From: Nicola Moore
Sent: 29 January 2021 11:25
To: chris barrow
Subject: RE: 2 Lindsey cottages - revised plan

[As Proposed.]

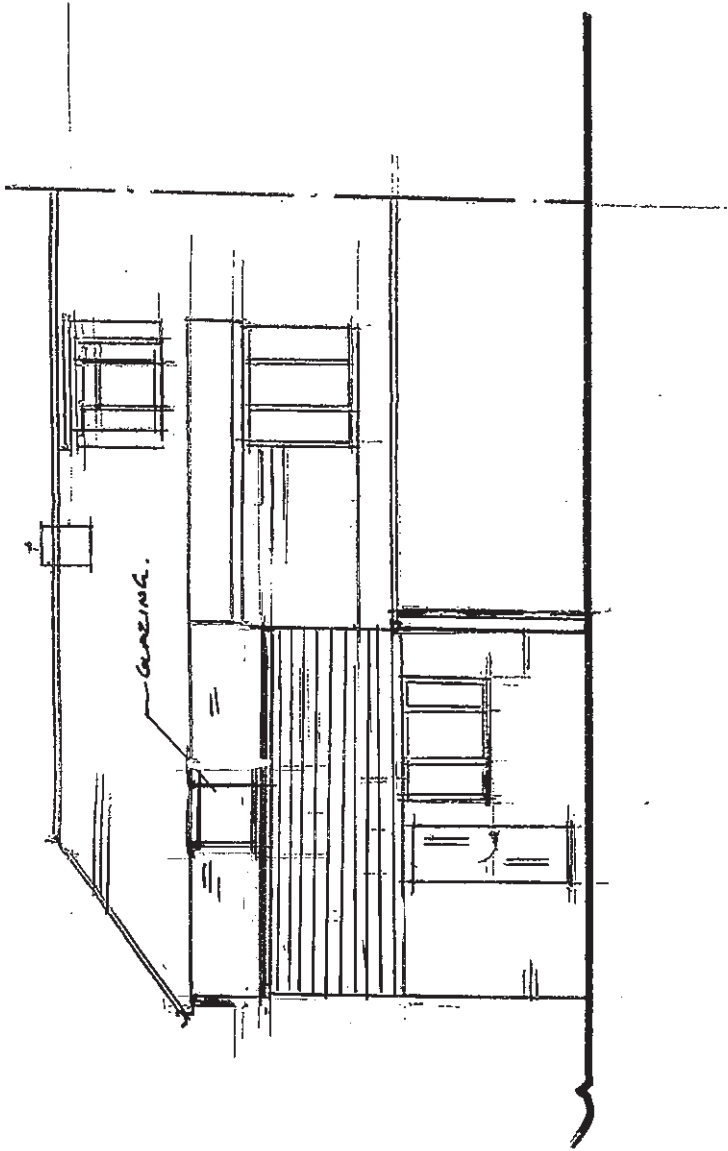
Proposed Elevation received 6/1
1st Floor window (bedroom) = 1.3m
Extension = 4.6m

Please check the measurements, amend accordingly and re submit the plans at the correct scale.

1ST FLOOR PLAN
[As Prop^d]
[1:50]

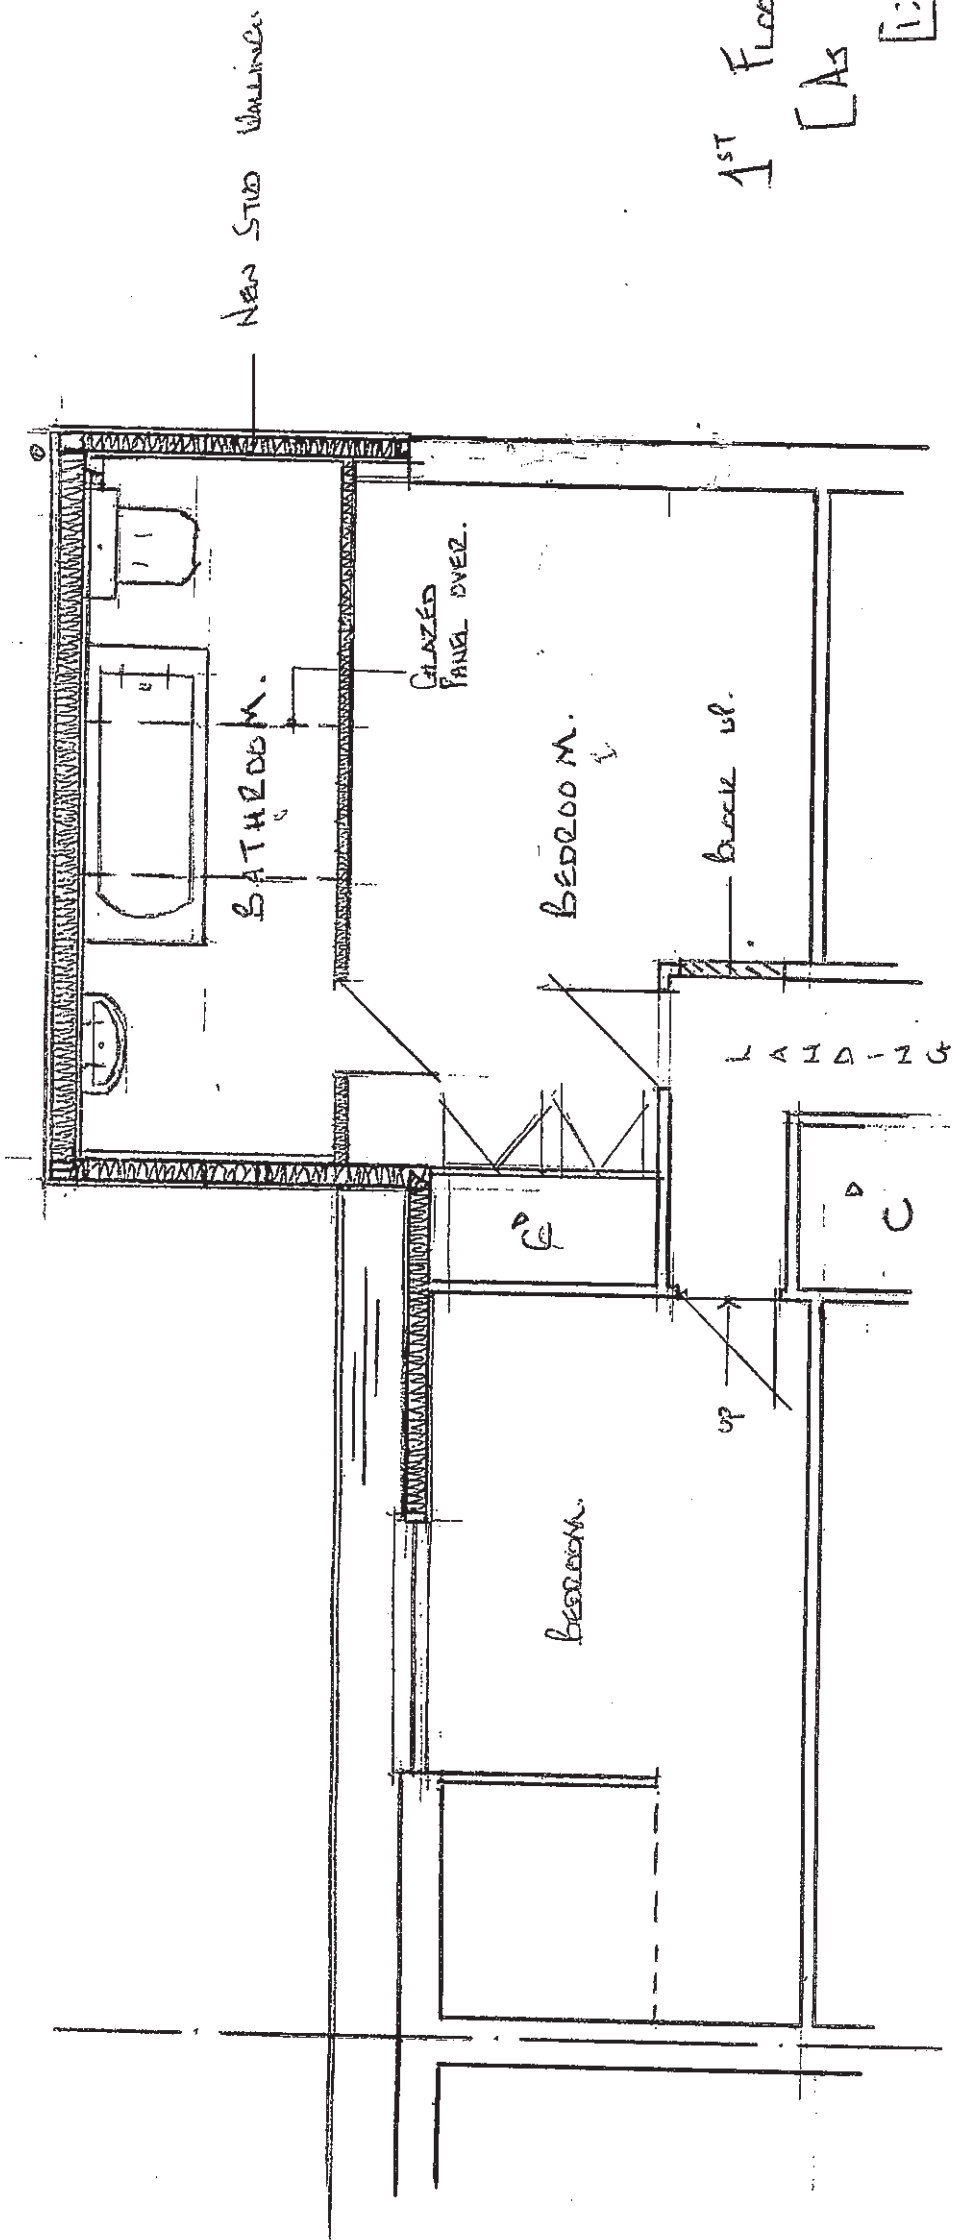
Proposed 1st Floor Plan received 27/1
1st Floor window (bedroom) = 1.1m
Extension = 3.4m
